Online Comment

Application H19-0757-18
Location The Oaks 251 Broadgate Road Sutton St Edmund PE12 0LT
Proposal Conversion of redundant agriculture building to one residential dwelling

Name Ian Marshman, Historic Environment Officer
Address Lincolnshire County Council Places Team Lancaster House 36 Orchard Street LN1 1XX

PROPOSED ELEVATIONS 1:100

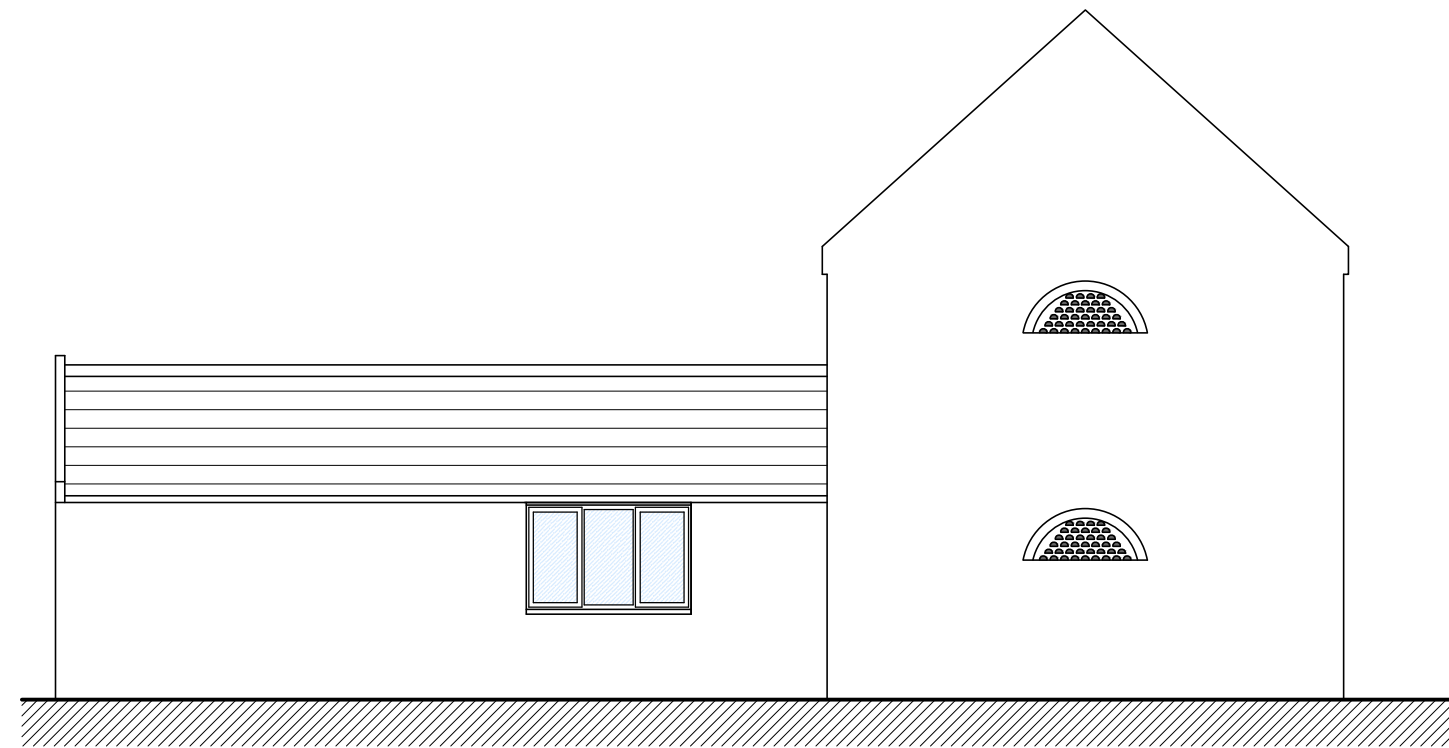
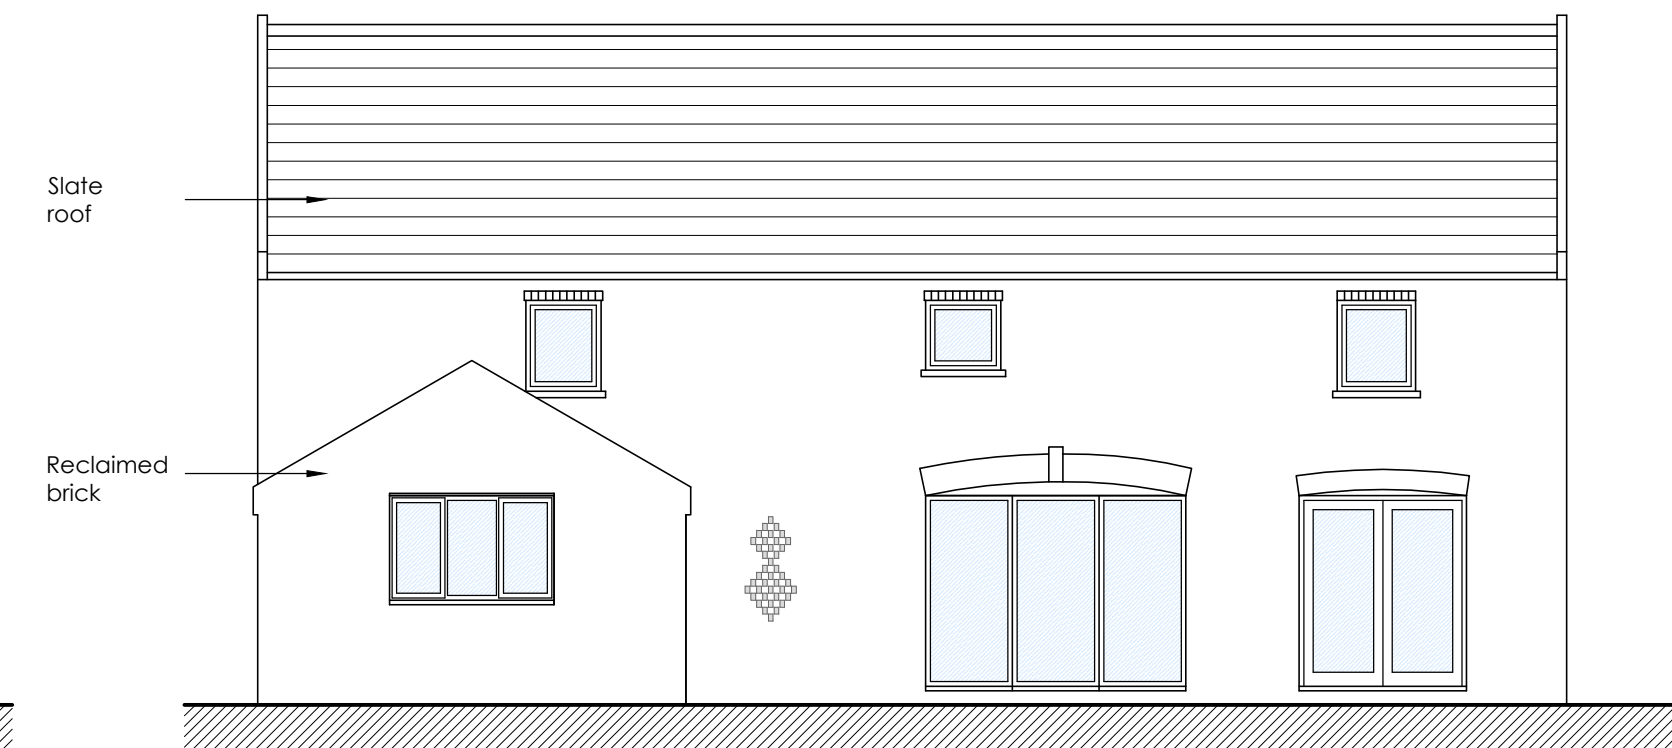
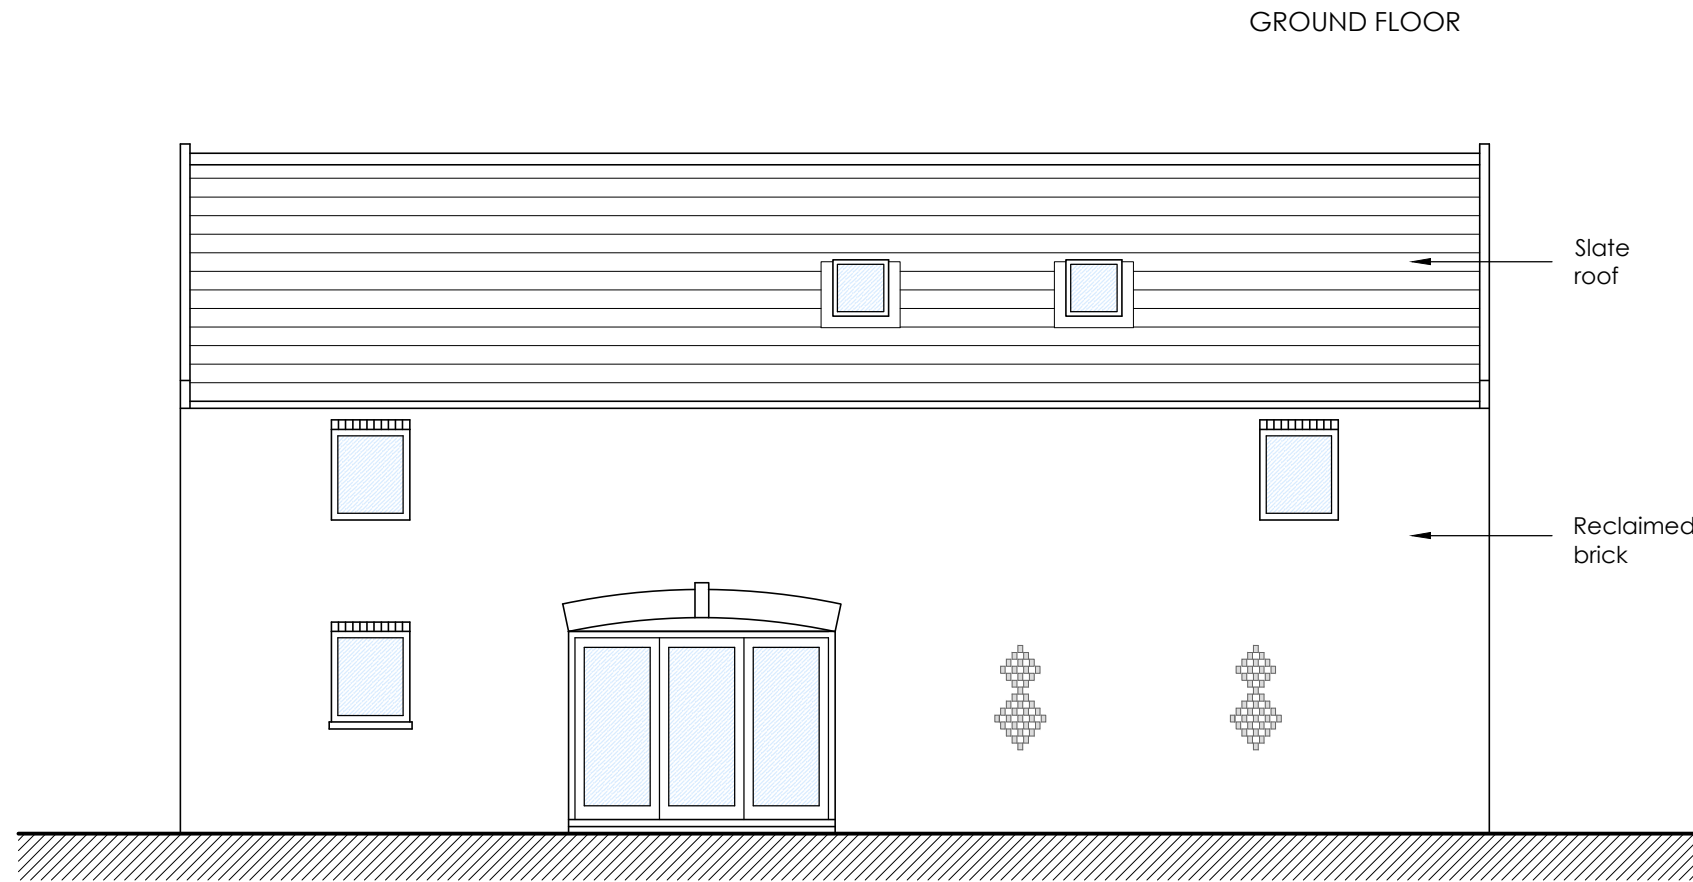
The present application also includes a number of amendments to the previously approved plans, which would lead to a less sensitive conversion that would harm the significance of this non-designated heritage asset. This consists of proposals to remove the three historic carriage arches and rebuild them at greatly reduced height and completely removing the rails on which their historic doors hang, presumably in order for the arches to light only the lower storey of the converted dwelling.

The pair of large doors facing each other on the East and West elevations had an important practical function, to allow a fully laden wagon to enter and unload the harvest, and then provide a through draft to ease with the laborious process of threshing and winnowing that separates the grain from the straw and chaff. The stature of this large and attractively detailed threshing barn attests the abundance of this fenland area after drainage, but the proposed alterations would disfigure this. In addition to the aesthetic harm to the building's significance, the inability in future to interpret the building's historic function would further harm the non-designated heritage asset's significance, which under the NPPF (revised 2018, section 16, paragraph 197) merits due consideration in any planning decision.

If the desire is not to have the inserted first floor cut across the double height openings created by the carriage arches, an appropriate and sensitive solution would be to block the upper part of the opening at first storey level using wooden boarding, as appeared to be proposed in the previously approved plans. This would also have the benefit of preserving the building's agricultural character by retaining the appearance of a barn door, particularly if the bi-fold doors on the ground floor are recessed in the reveal below.
